# CITY OF ALBUQUERQUE

January 24, 2017

**Re: Drainage Control Ordinance Violation**

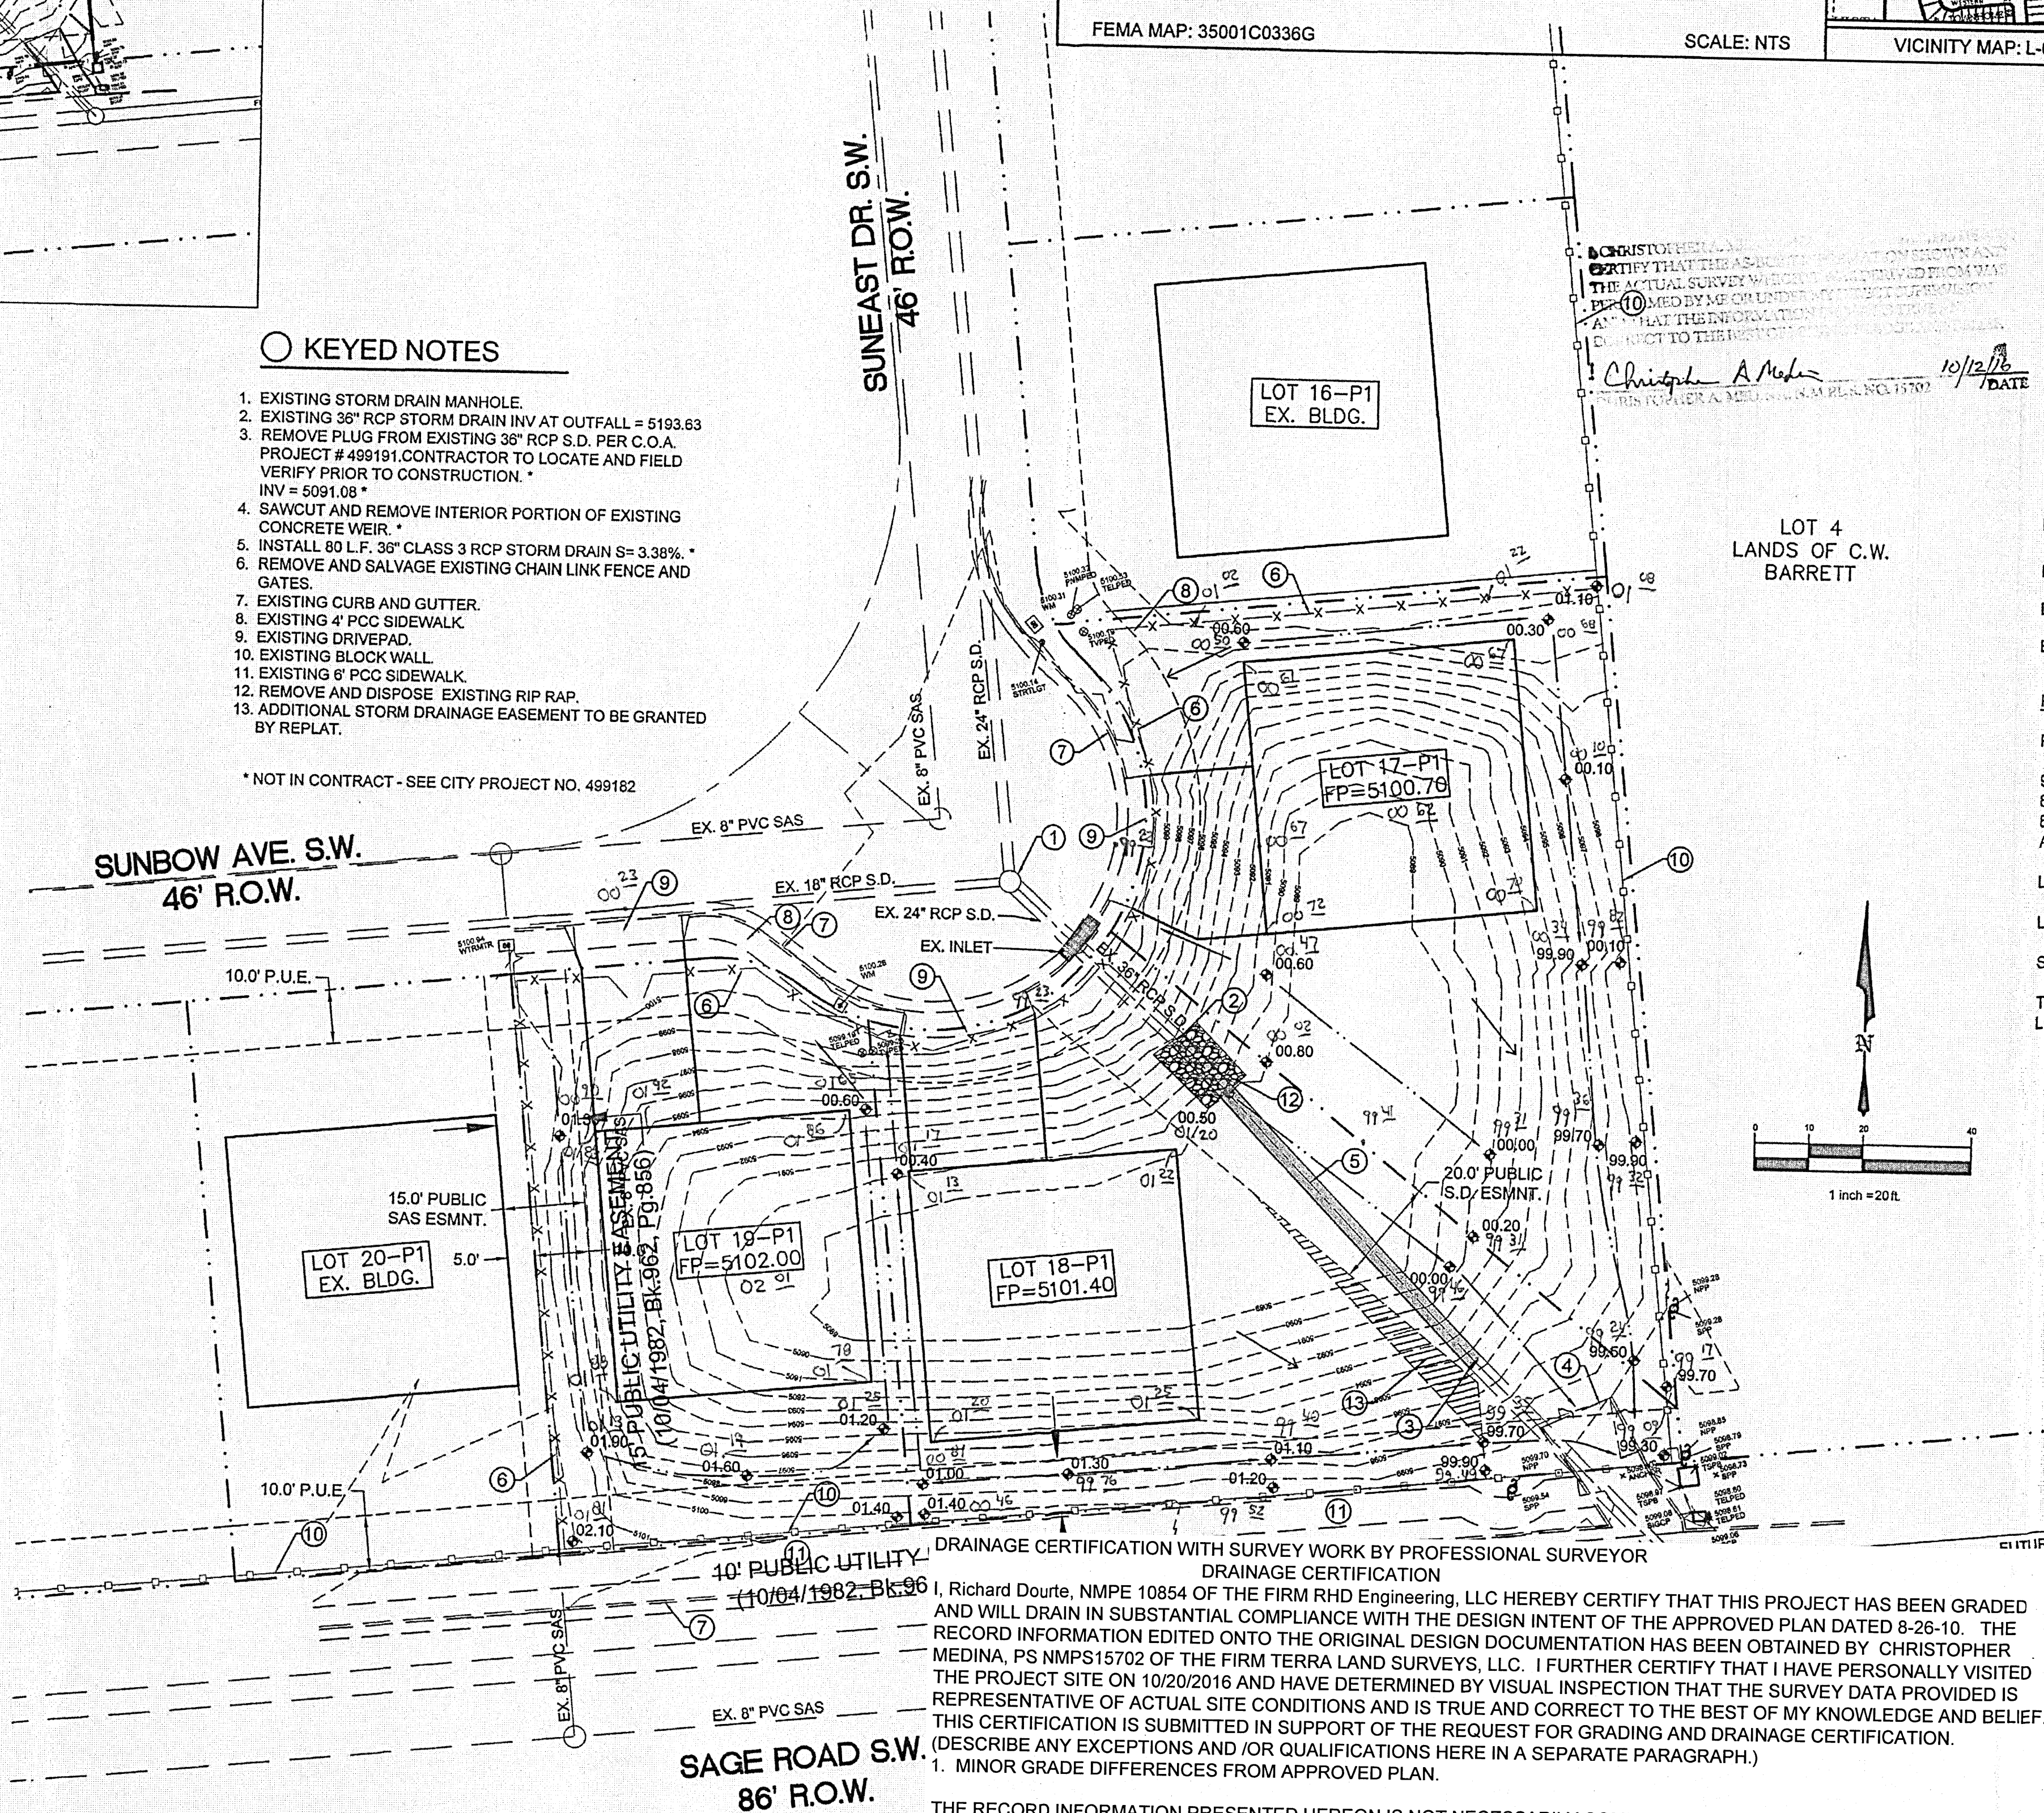
1. Install sedimentation pond per e-mail dated 12-9-16 or install a filter sock or silt fence in front of the holes in the wall.
2. Remove cement pollution from 920 Suneast Dr SW and provide an acceptable concrete/stucco/mortar washout-out.

A site visit was performed on January 23<sup>rd</sup>, 2017. Neither of the above mentioned violations had been mitigated.

In addition, sediment was observed on the ADA ramp/sidewalk on Sage Rd.

1. Install sedimentation pond per e-mail dated 12-9-16 or install a filter sock or silt fence in front of the holes in the wall. If a filter sock is to be used, it is to be staked down.
2. Remove cement pollution from 920 Suneast Dr SW. If more concrete/stucco/mortar work is part of the project, an acceptable (e.g. Outpak, hole lined with plastic, etc...) wash-out is to be used.
3. Remove sediment form the sidewalk/ADA ramp on Sage Rd.
